Contact: Chris Dwyer
Our Ref: DA 52/2025/10/1
Your Ref: SSI-70610456

**Request for Submission – Critical State Significant Infrastructure
Hunter Transmission Project (SSI-70610456)**

Thank you for the opportunity to make a submission on the Environmental Impact Statement (EIS) for the Hunter Transmission Project (HTP) proposed by EnergyCo.

Figure 6.6 Indicative transport routes to be used during the HTP's construction

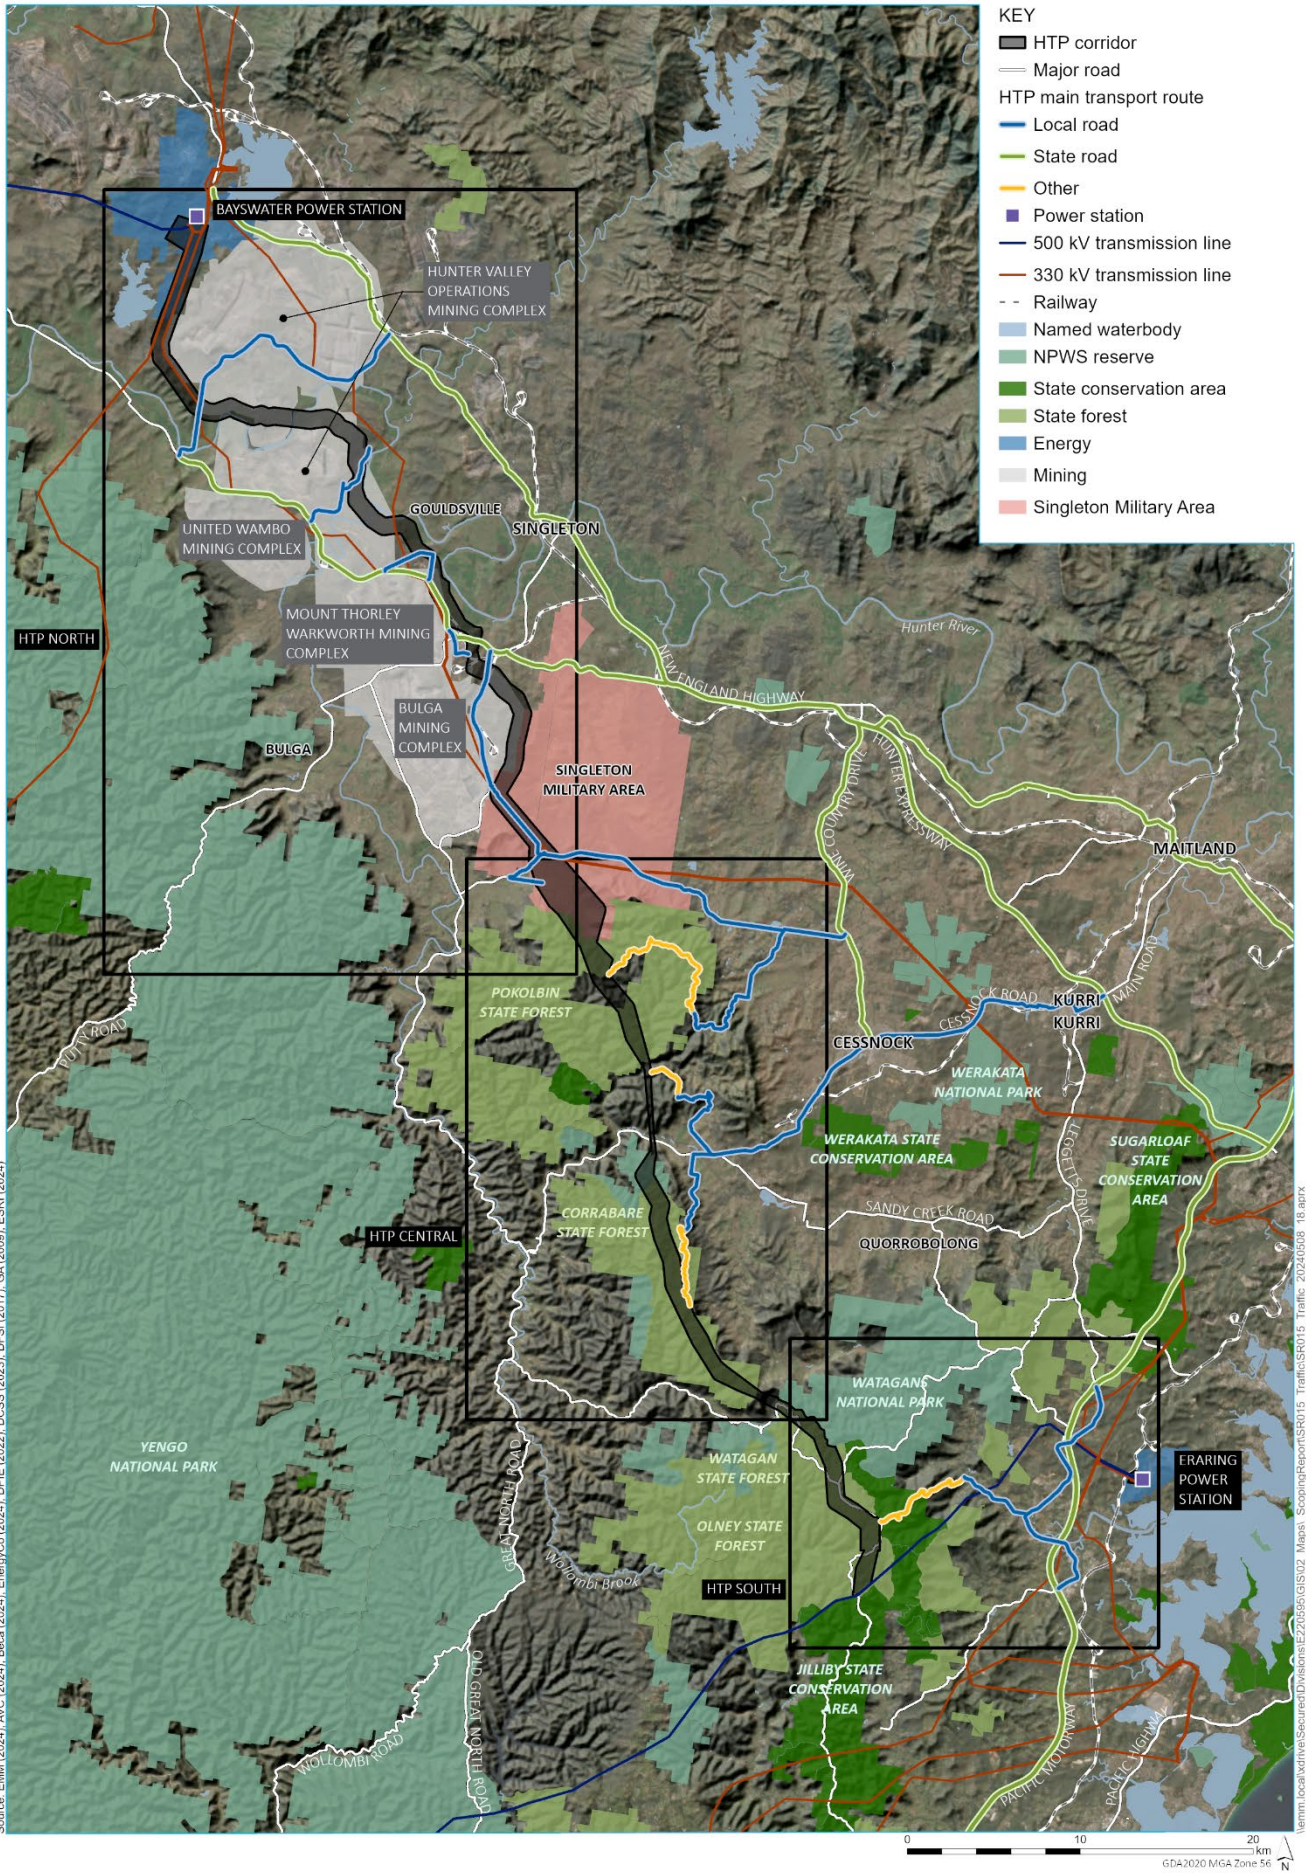
Many of these roads and intersections are narrow, partially unsealed roads with shallow culverts. Although pavements are currently in a good to fair state, they are not suitable for regular heavy vehicle traffic from a design and safety perspective. Particular concern is raised with Cedar Creek Road, Hayes Road (Mf1 Road), Mount View Road and Pokolbin Mountains Road.

The EIS would benefit from an analysis of alternate routes that may have been considered and reasons they are not preferred. Particular reference is made to any alternate routes from the Hunter Expressway to Cessnock from the east (including Hart Road access), and any routes from the Hunter Expressway from the north (including Wine Country Drive access) to either Cessnock / Broke Road / McDonalds Road.
